MLC School Rowing Program  
Rowley Street  
Burwood NSW 2134

14 November 2019

**Re SSD 8924 - New Sydney Fish Market Concept and Stage 1 Early Works**

**Diagram : Proposed Relocation Of Rowing Route**

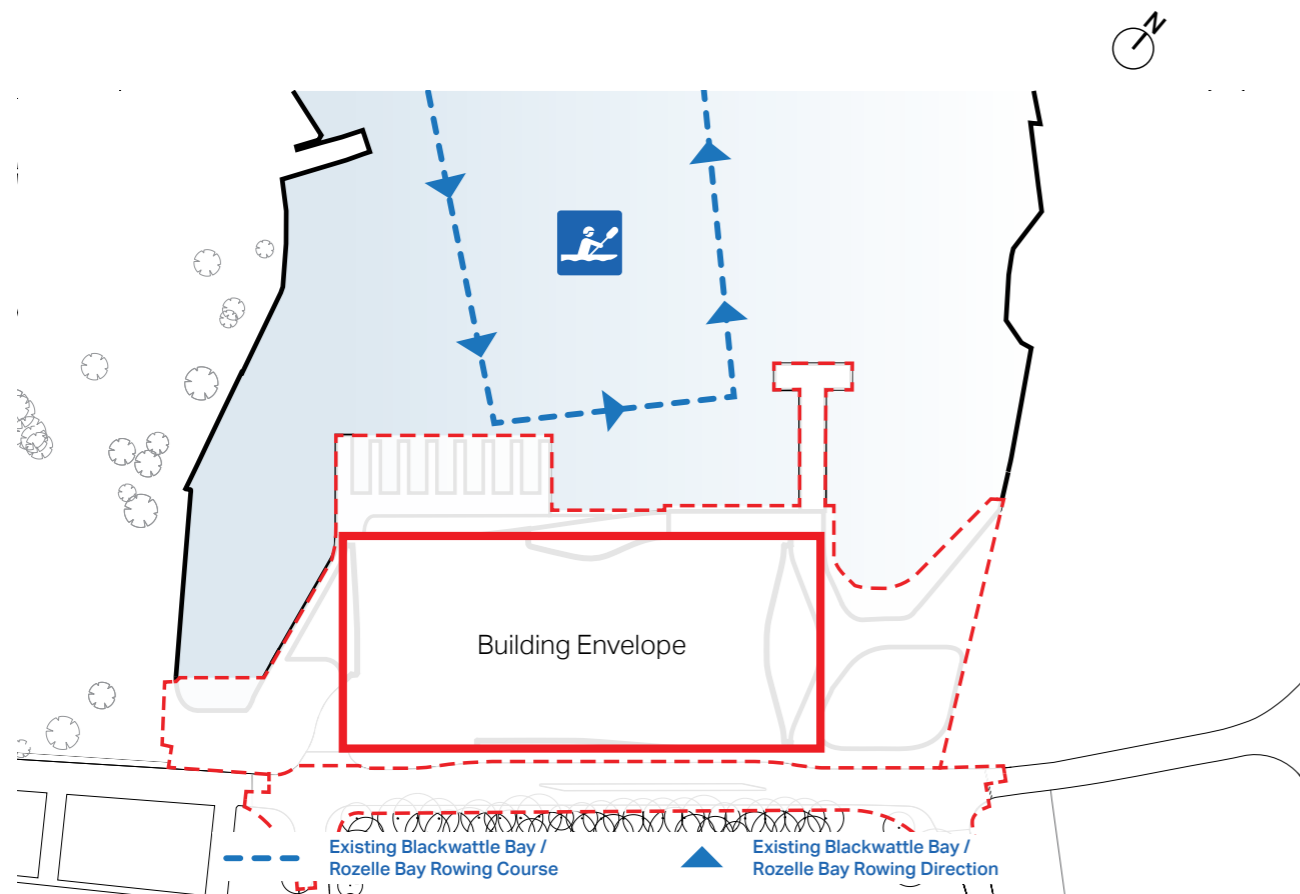
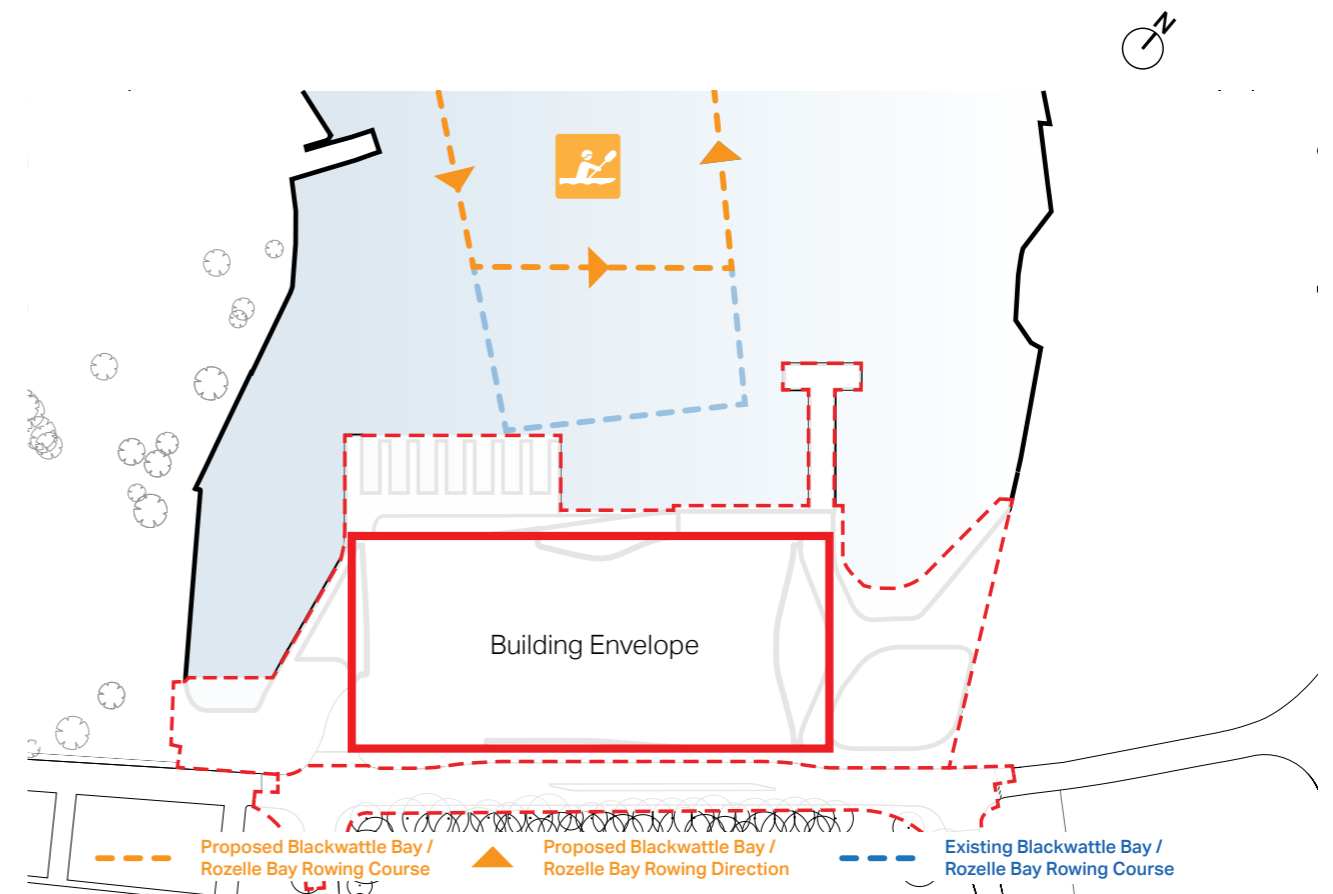
The current design includes an Eastern public wharf designed to accommodate motorised recreational vessels and a ferry stop. The proposed wharf structure extends an additional 65m into Blackwattle Bay and it is proposed that the current agreed rowing course be shortened by 45m to accommodate for the new wharf.

We recognise compromise in a complex project like this is required, but the correct impact on the rowing course of the current design of the East wharf plan is much greater than currently noted and creates an unnecessary safety risk. This is not helped by the omission of Glebe Rowing Club and its pontoon from most of the major relevant diagrams including those in A3 Vol Appendix 1 Concept Drawings and A3 Vol Appendix 2 Concept Design Report Part 3.

The current rowing course is designed to ensure rowers travel 'with traffic' to take a safe position on the opposite side of the Bay and in accordance with Roads and Maritime Boating Handbook. From that position they safely turn before heading down the east side of the Bay closer to the shore thus avoiding any traffic in the opposite direction that has drifted to the middle of the Bay.

We currently muster and turn where the Eastern Wharf is planned to end. Even with a reduced rowing route, we estimate that our turning circle would put us directly in front of the new wharf. When including ferry services likely to be placed at the front of the wharf, rowing boats would be mustering around 20m from the wharf.

We request that the wharf be shortened by at least 25m to restore the safe distance from the actual turning circle of boats and the wharf.

**Diagram : Wharf - Recreational And Ferry**

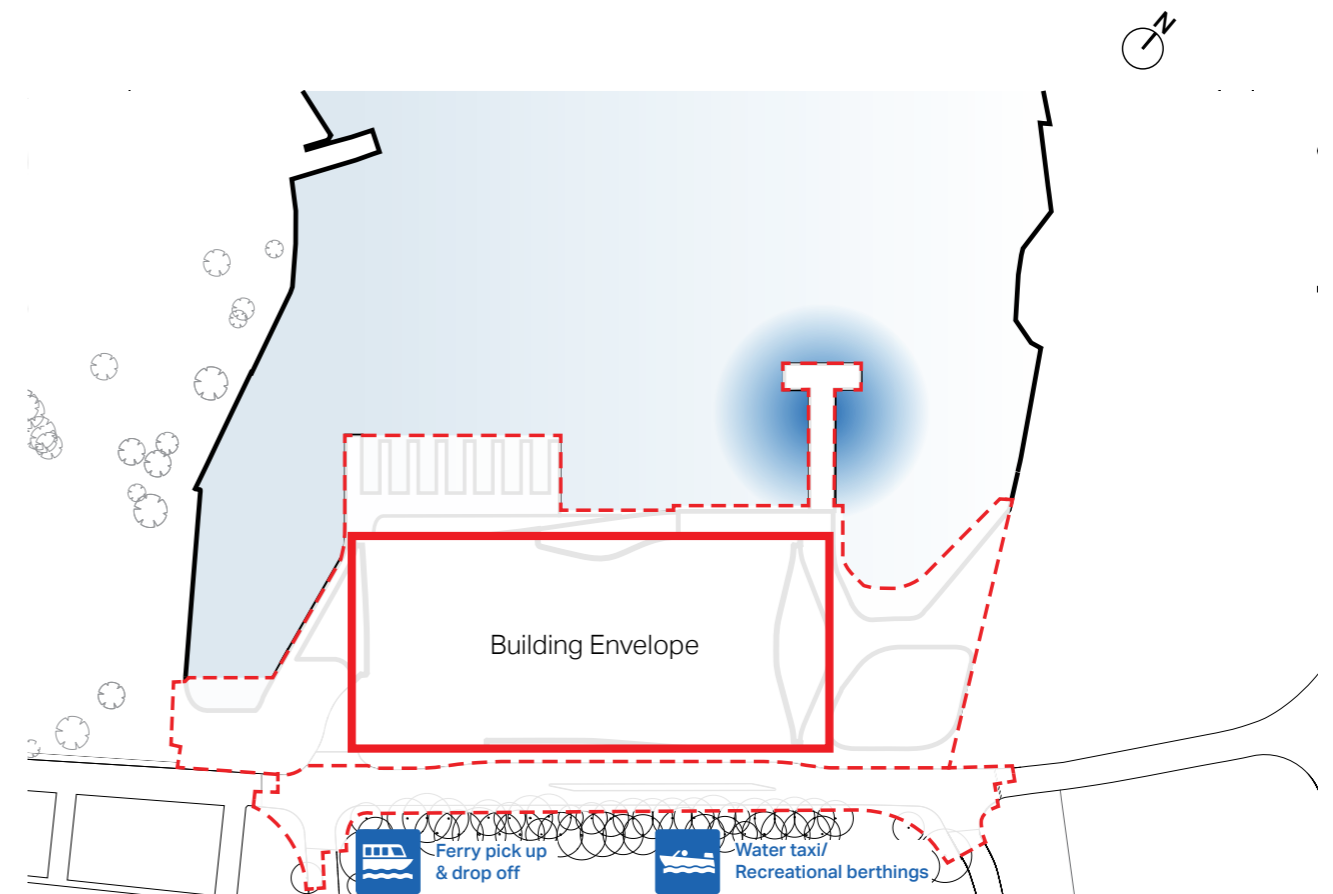
- There appear to be no estimates of day-tripper arrivals to the Fish Markets by small powered vessels – either currently or into the future – to justify the size and positioning of the Eastern wharf.
- There appear to be no estimates of either the current use of the public ferry or of the size of increases in its use in the future. We have recently seen the introduction of the on-demand ferry service, which we expect will grow once the Fish Market development is complete.
